### **OUR CLIENTS: MR RICHARD GILL, MRS LISA GILL & DRONE DEFENCE SERVICES LTD SUBMISSIONS FOR DEADLINE 5**

# Cauntton Lodge Farm, Norwell Woodhouse.

Landscape Technical Note including Residential Visual Amenity  
Assessment (RVAA)

April 2026

R27: Cauntton Lodge Farm (240 m)

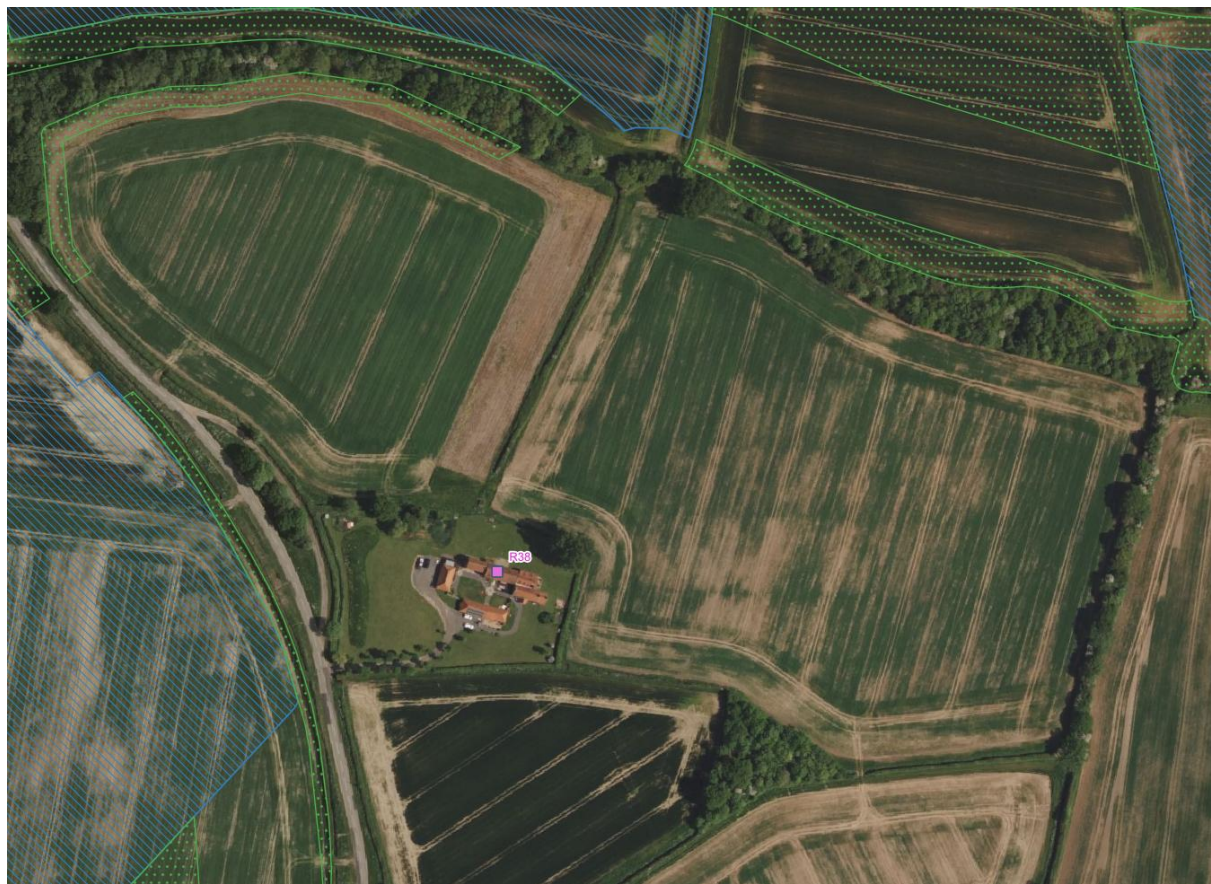
views from private properties. This technical note also gives consideration to the RVAA undertaken by the Applicant and identifies potential inconsistencies in the baseline and how the hierarchy of mitigation measures does not appear to have been consistently applied across the wider project.
